METHODS FOR TESTING EROSION THRESHOLD VELOCITY (ETV)

METHOD 1 – COLLECTION OF AN UNDISTURBED SOIL SAMPLE SUITABLE FOR LABORATORY-BASED ETV TESTING

0-0080-900-IHY-00-PR-0001

Review of Collection of Undisturbed Soil Samples, Revision C:
NSW/QLD Border to Gowrie Section of the Inland Rail Project

Figure 6: Sampling frame.

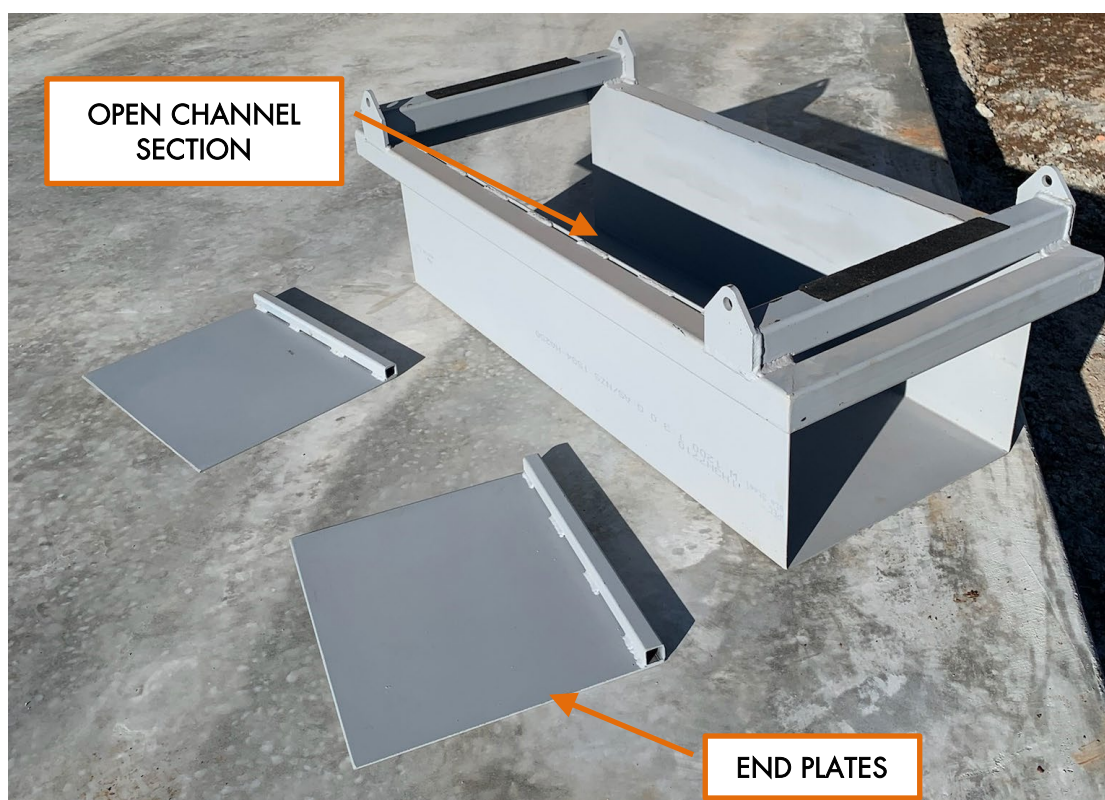
The dimensions of the sampling tray and the depth of the soil sample are not fully stated. Could the authors please provide the material (steel? aluminum? stainless?) and thickness (mm, inches or gauge) of the sampling box, the depth of the sampling box and the depth of the soil

sample that is to be collected? In addition, could the length, width, height and thickness of the aluminum sleepers be provided? How many anchors were necessary for the sleepers to ensure they didn't move? Such information could be useful for others wishing to use a similar collection method, or for Landloch's archives should a similar study be carried out in the future following a staff turnover.

The dimensions of the sampling tray and the depth of the soil sample are not fully stated. Could the authors please provide the material (steel? aluminum? stainless?) and thickness (mm, inches or gauge) of the sampling box, the depth of the sampling box. and the depth of the soil sample that is to be collected? In addition, could the length, width, height and thickness of the aluminum sleepers be provided? How many anchors were necessary for the sleepers to ensure they didn't move?	These details were included in Section 4.1 for the sampling frame and 4.2 for the guide sleepers.
Section 4.1, paragraph 3, how was the bulk density measured? Was the soil in the sample tray disturbed, or was a sample taken from nearby in the field? Was the bulk density measured in the lab from the tray before or after the runoff treatment?	Detail on how the sampling for bulk density was achieved was added in Section 4.1.
